**WELWYN HATFIELD BOROUGH COUNCIL
EXECUTIVE DIRECTOR - PLANNING, PUBLIC PROTECTION AND GOVERNANCE**

DELEGATED APPLICATION

Application No: 6/2017/2964/MAJ
Location: Blue Moon Paddock Woodfield Lane Brookmans Park AL9 6JJ
Proposal: Demolition of existing redundant structures and erection of single family dwellinghouse (within envelope of existing structures), together with associated tree planting scheme (part of Centenary Woods project sponsored by Woodland Trust); landscaping and car parking
Officer: Mr Mark Peacock

Recommendation: Refused

Drawing No.
P/502/B

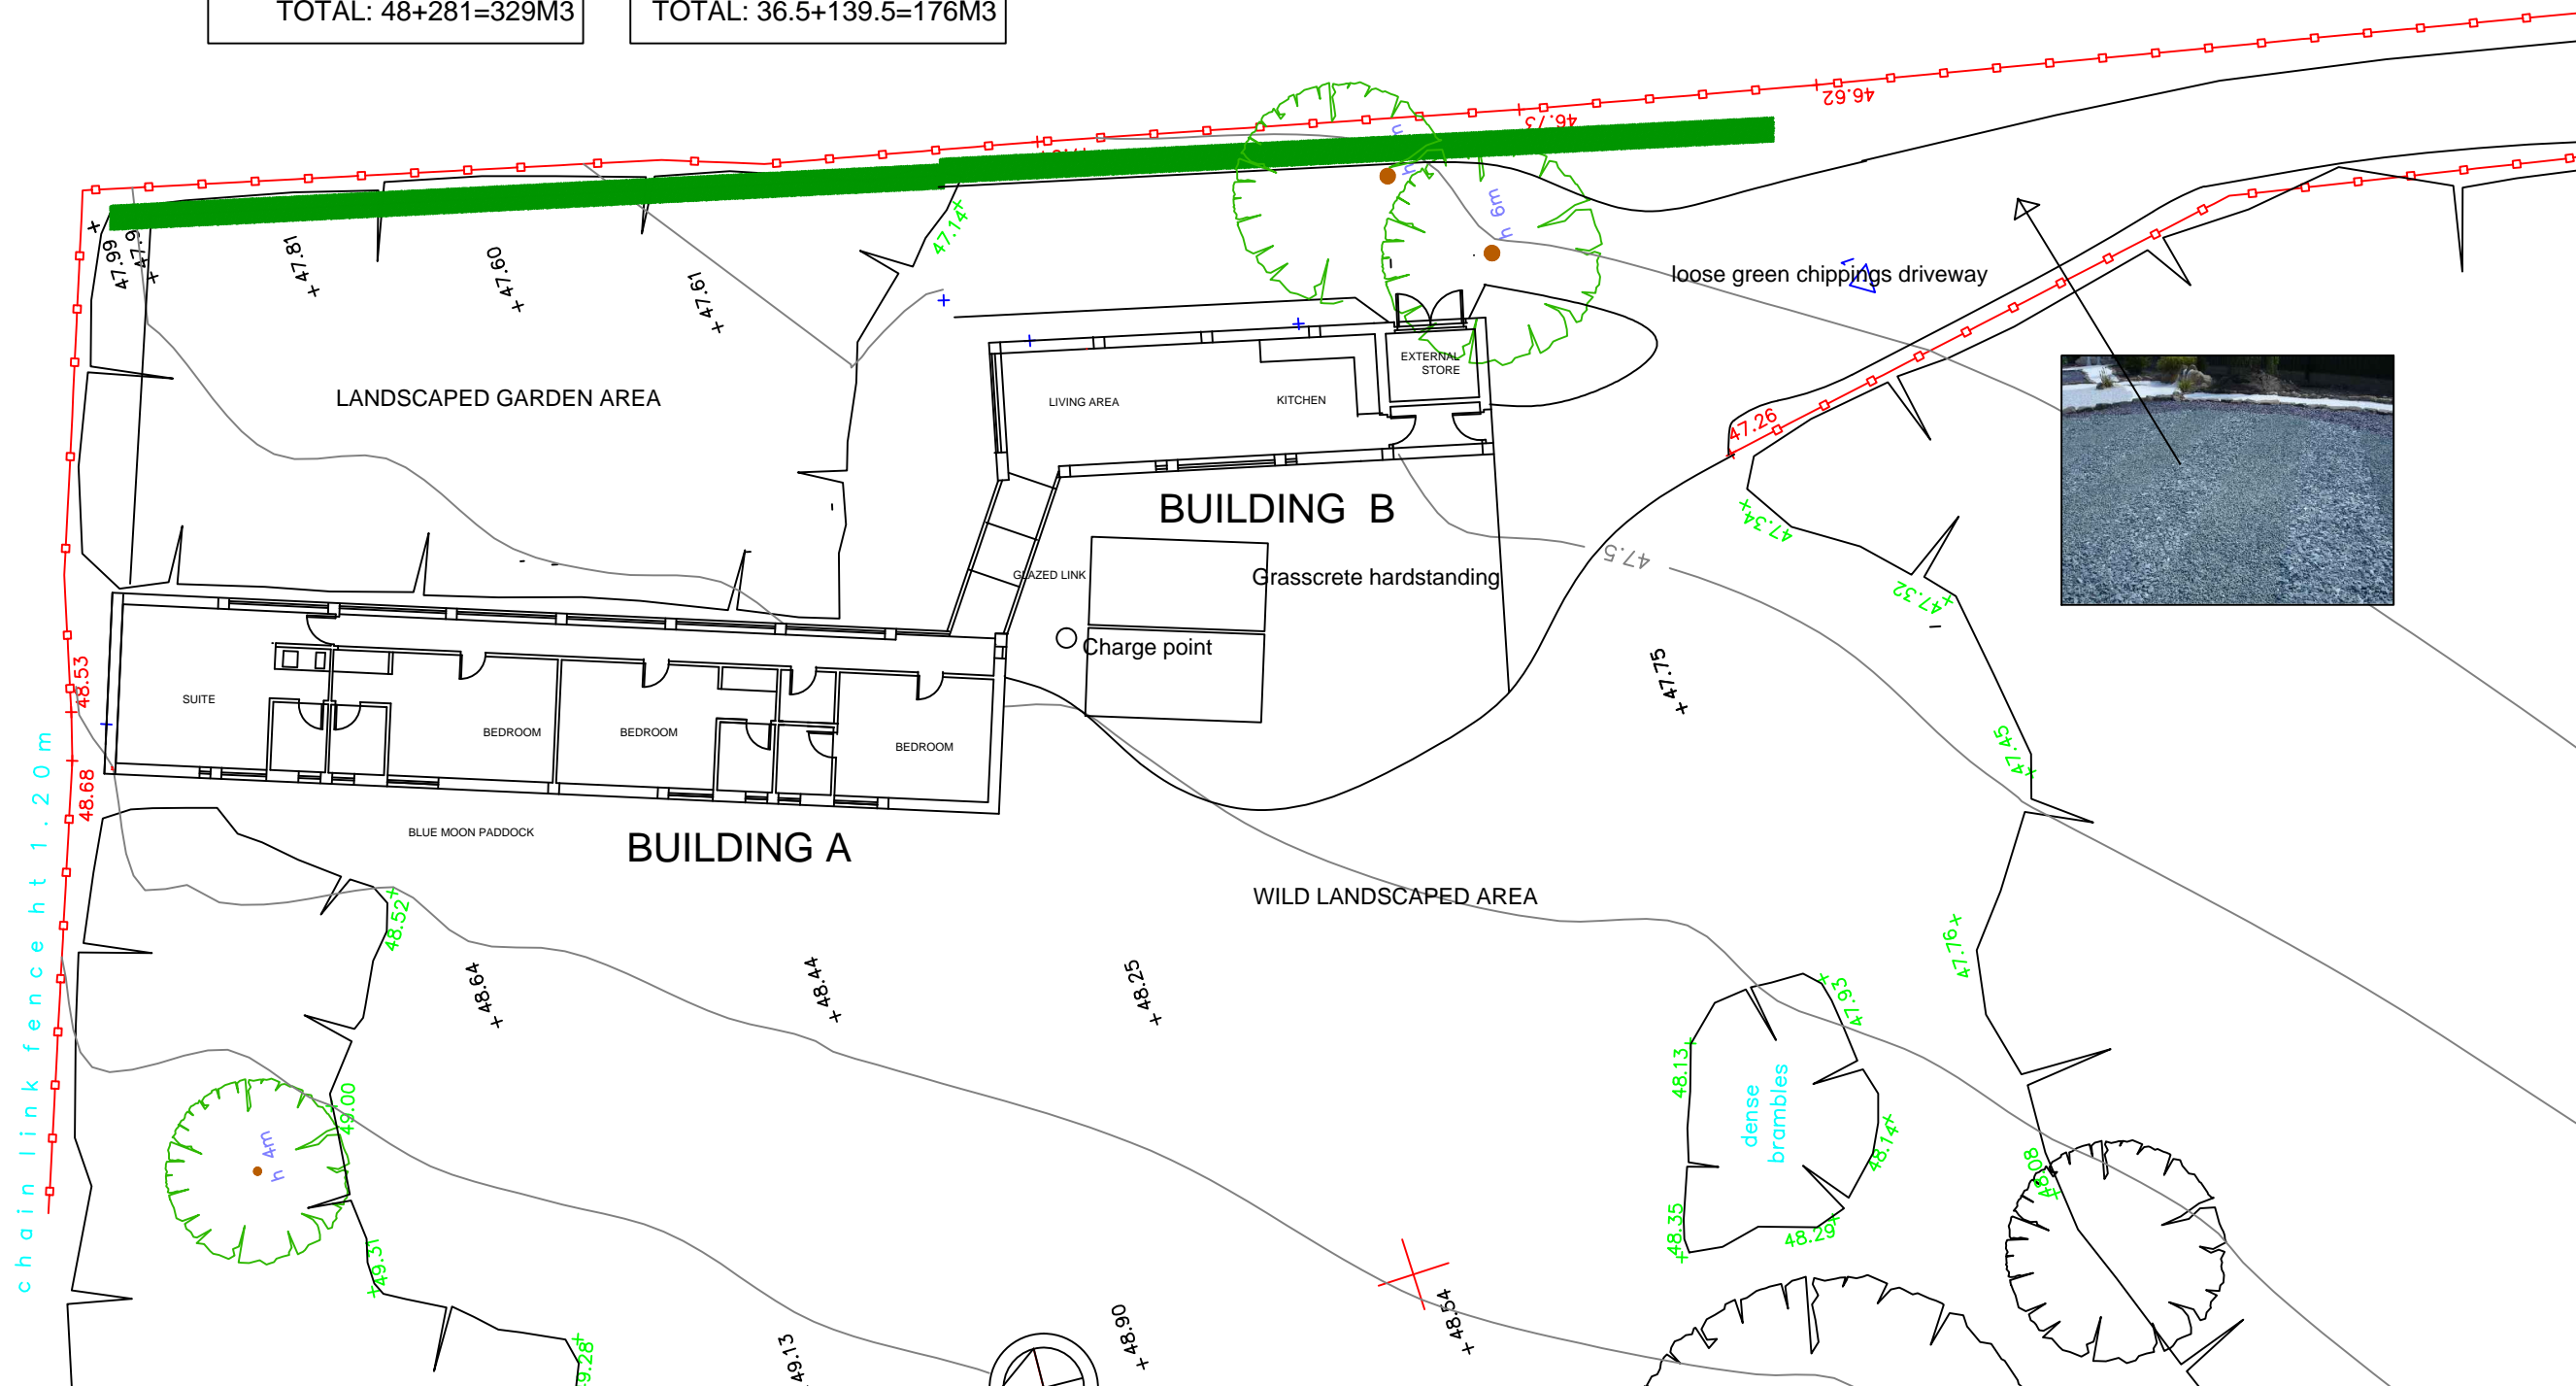
The Proposed Site Plan (P/502B) shows the access road and parking area. A "landscaped garden area" is annotated to the north east corner of the site and a "wild landscape area" to the west of the proposed dwelling. Whilst a detailed landscaping scheme, including boundary treatments and hard landscaping features, could be secured by condition, there remains a strong likelihood that domestic uses would extend beyond the residential curtilage to the wild landscape area and woodland beyond. The introduction of hard boundary treatments or formal landscaped boundaries would not be appropriate to the character of the site and would result in harm to the Green Belt openness in their own right.

Drawing No.
P/505/A

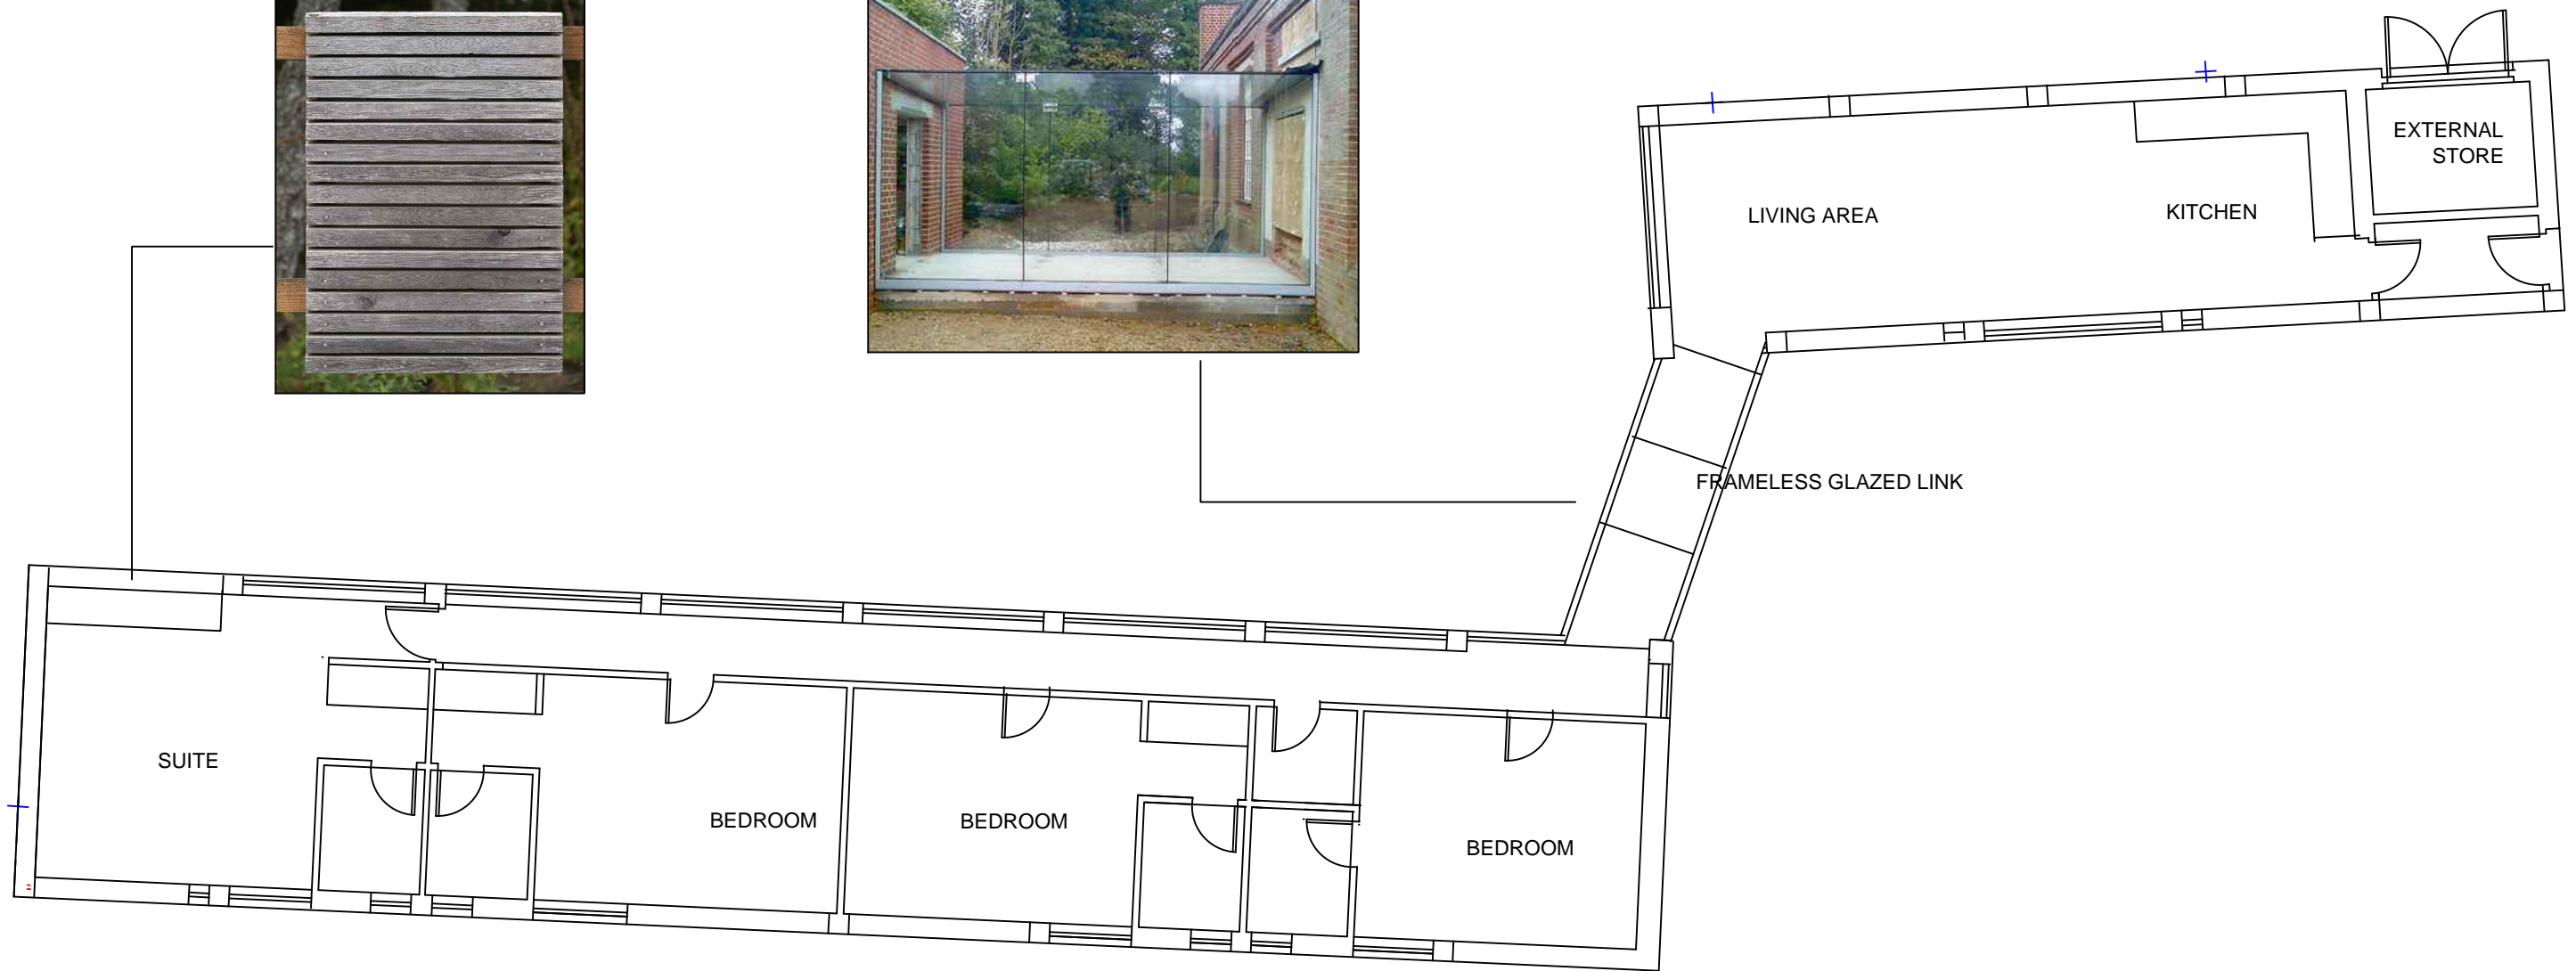
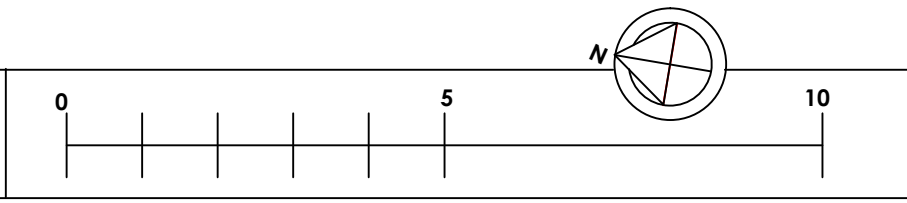
A notable characteristic of the proposal is the addition of large areas of glazing, including a floor to ceiling window which is approximately 9m in length along the east elevation of Building A, the fully glazed link between Building A and B, as well as large floor to ceiling windows on the north elevation of Building B and the west elevations of both Building A and Building B. The visual impact of adding fenestration results in a building which is of a domestic character, particularly after dark when they would appear illuminated within what is otherwise a dark setting.
